Re: Objection to SSD 7684: Cockle Bay Wharf Redevelopment (Concept Proposal) ("Application") as modified by Response to Submissions Report

We act for the owners of Strata Plan 49259 comprising the major residential development known as One Darling Harbour.

We refer to the exhibition of the Application as modified by the proponent's Response to Submissions report dated 5 July 2018 (**RTS Amended Proposal**).

Fig. 27. Artist Impression by Doug & Wolf (Indicative render - subject to design competition)

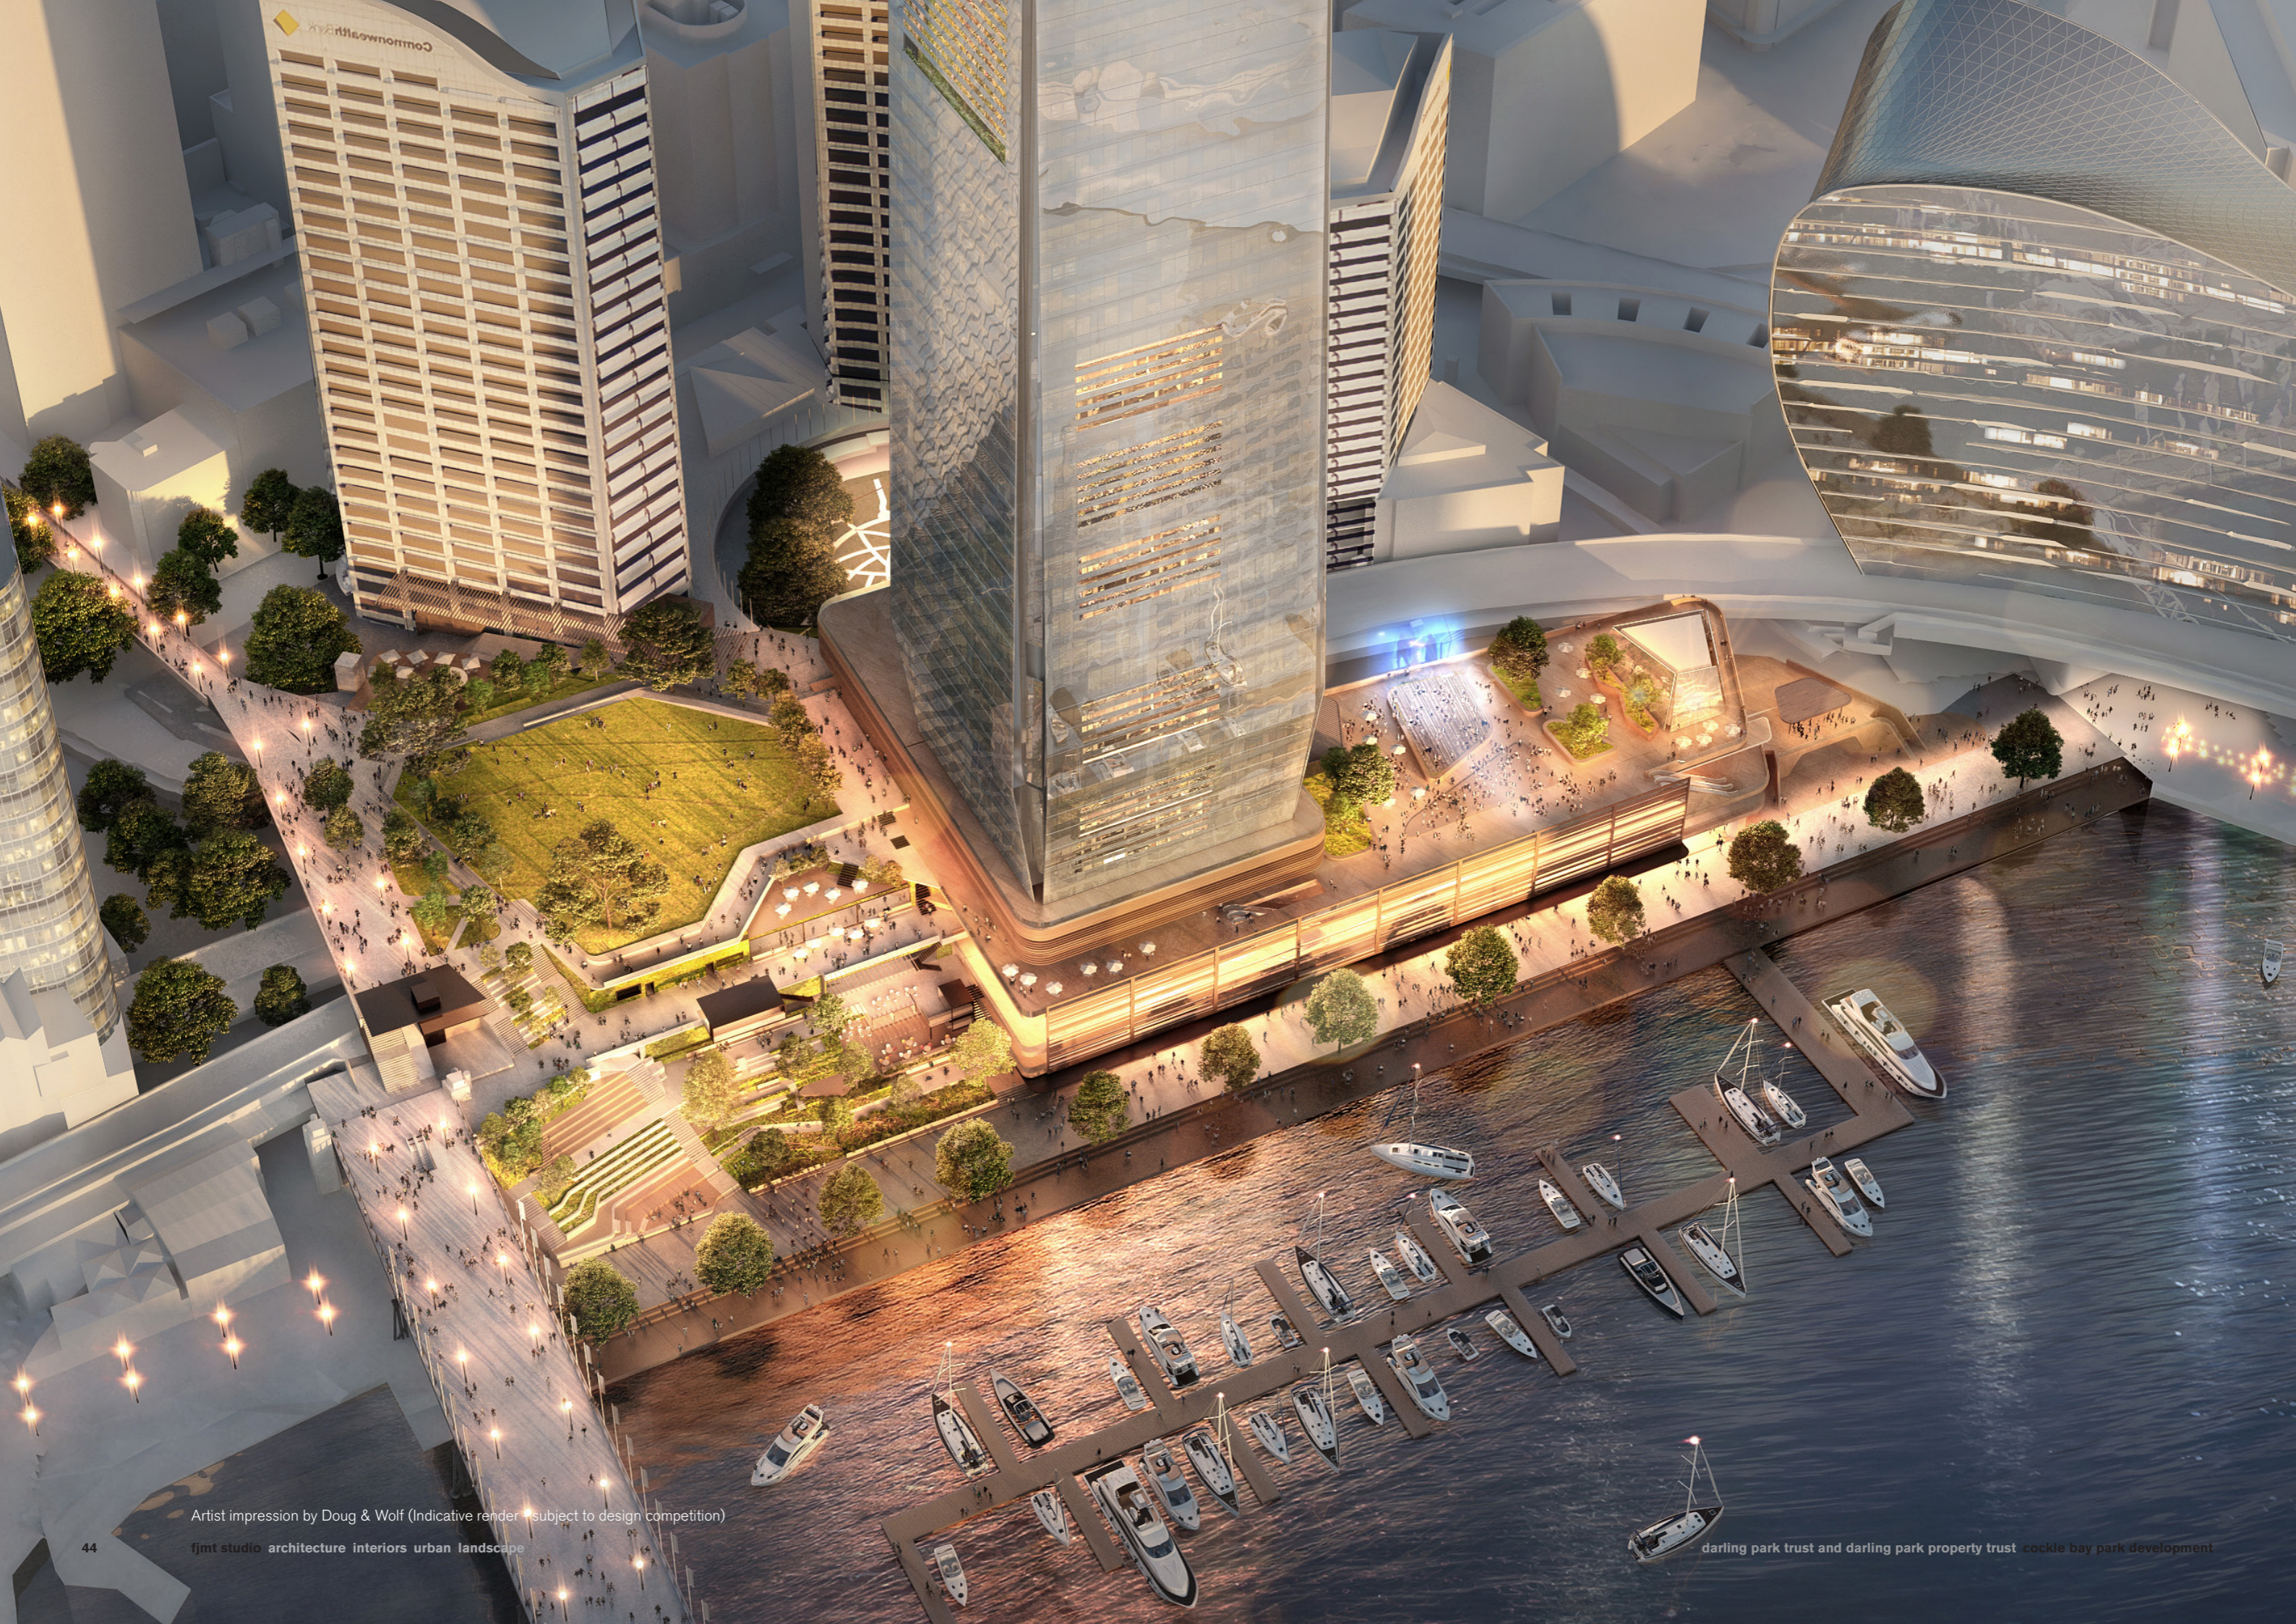
3. The height, bulk and scale of the development and the proximity of the tower to the waterfront remains inconsistent with the 2005 SREP and accepted principles of urban design. The adverse impact of the proposal on the waterfront is evident in the images in Figures 27, 28 and 34 of the RTS: Appendix D Supplementary VVIA Report. The RTS has incorrectly characterised our client’s submission as limited to “Statutory and Strategic”¹. Our client also objects to the proposal on the basis of “Urban Design and Built form”, “Visual Impact”, “Public Domain” and “Public Interest”. The minor amendment of the design has not altered our client’s submissions on these issues.
